Our reference: ECM: 9030543
Contact: Gavin Cherry
Telephone: 4732 8125

26 February 2020

St Marys Intermodal, Forrester Road, St Marys (SSD-7308) – Request for Advice

Figure 2: Access Road Driveway Paths (Source: BG&E)

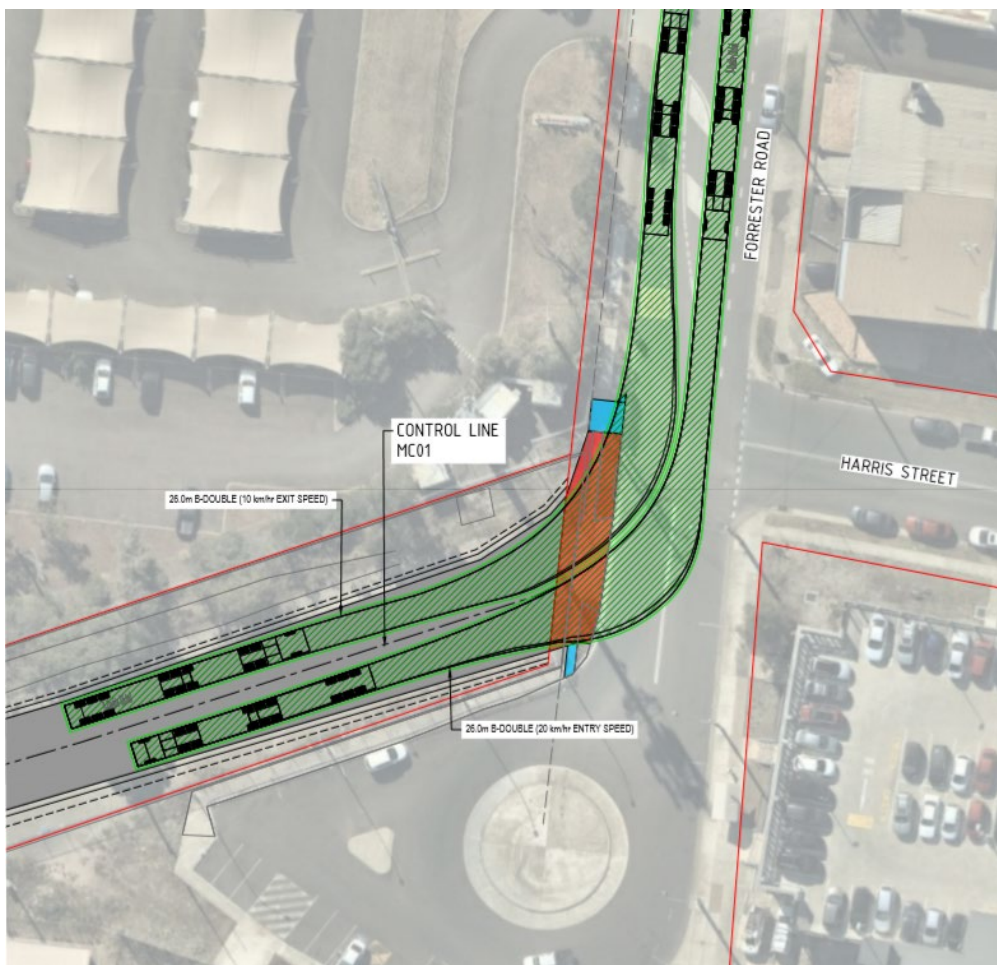
- The access driveway widths must accommodate swept movements of the largest vehicle servicing the site and be designed to conform with AS 2890.2.
- Sight distance requirements and driveway widths are to be met in accordance with AS/NZS 2890.1: 2004 and Council requirements. This is to include the requirements set out in AS 2890.1 Figure 3.2 Sight Distance Requirements at Driveways and Figure 3.3 Minimum Sight Lines for Pedestrian Safety. Also AS 2890.2 Figure 3.3 Sight Distance Requirements at Access Driveway Exits and Figure 3.4 Minimum Dimensions for Access Driveway Sight Splays for Pedestrians.

Figure 3: Proposed signage and access point widening for St Marys Freight Hub (Source: BG&E)

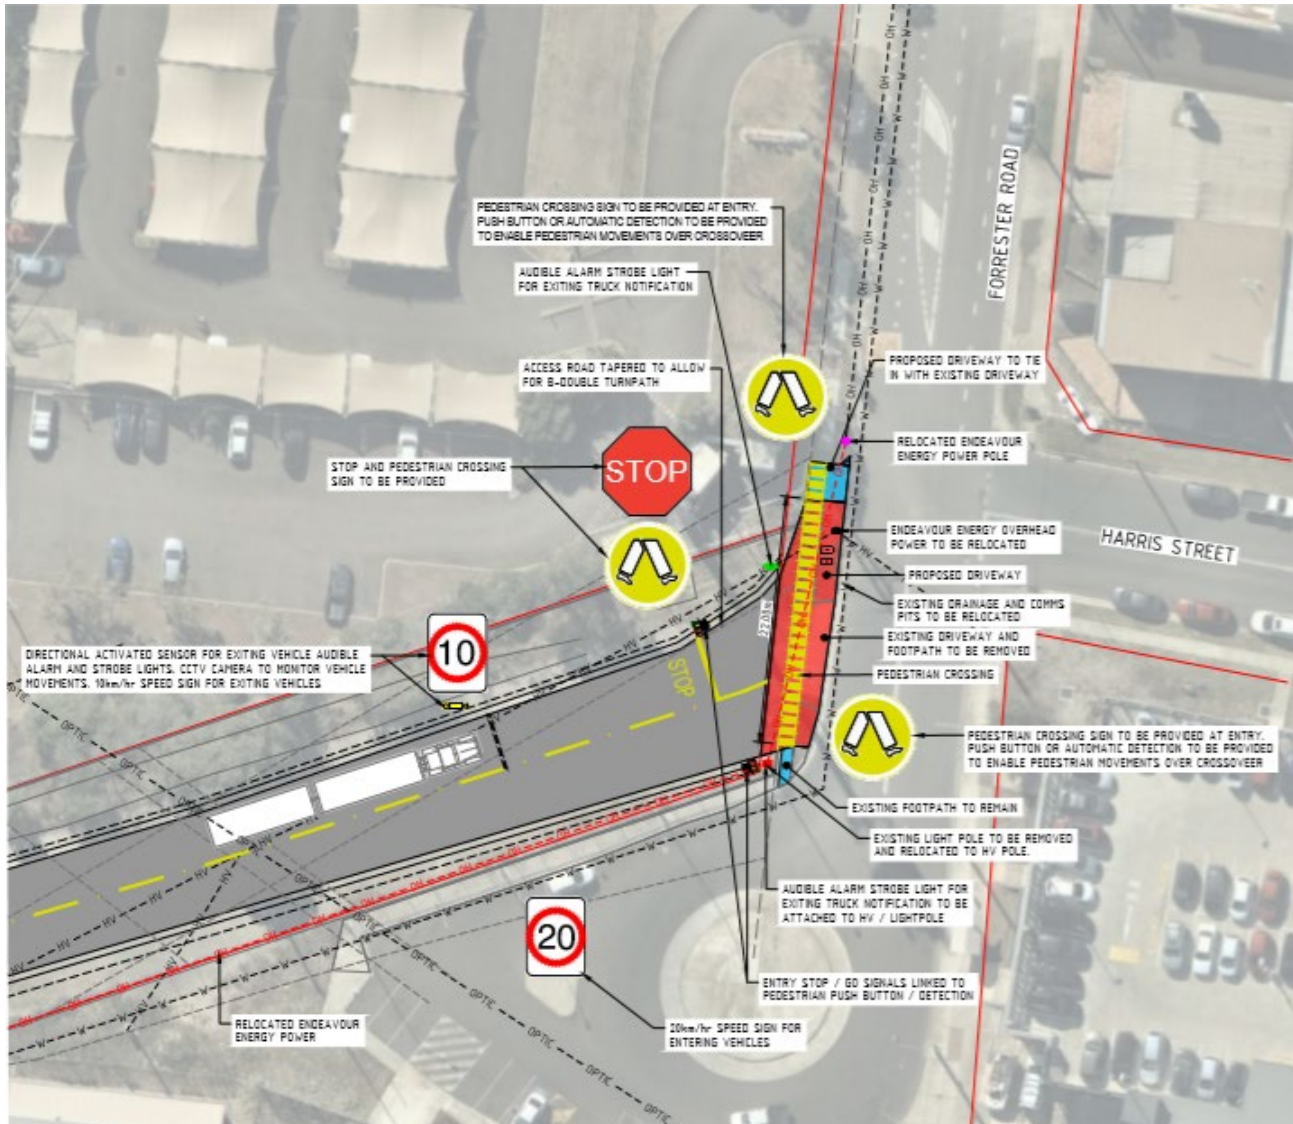
- The car park entry / exit should be separate from the heavy vehicle entry / exit driveways.
- Separate accessible pedestrian access is to be provided from the footway and the car park to the building entrance in accordance with AS 2890 car park access and AS 1428 Mobility accessible paths of travel.

- The required sight lines around the driveway entrance and exit are not to be compromised by street trees, landscaping, fencing or signposting.
- All car parking and manoeuvring must be in accordance with AS 2890.1, AS 2890.2, AS 2890.3, AS 2890.5, AS 2890.6 and Council requirements.
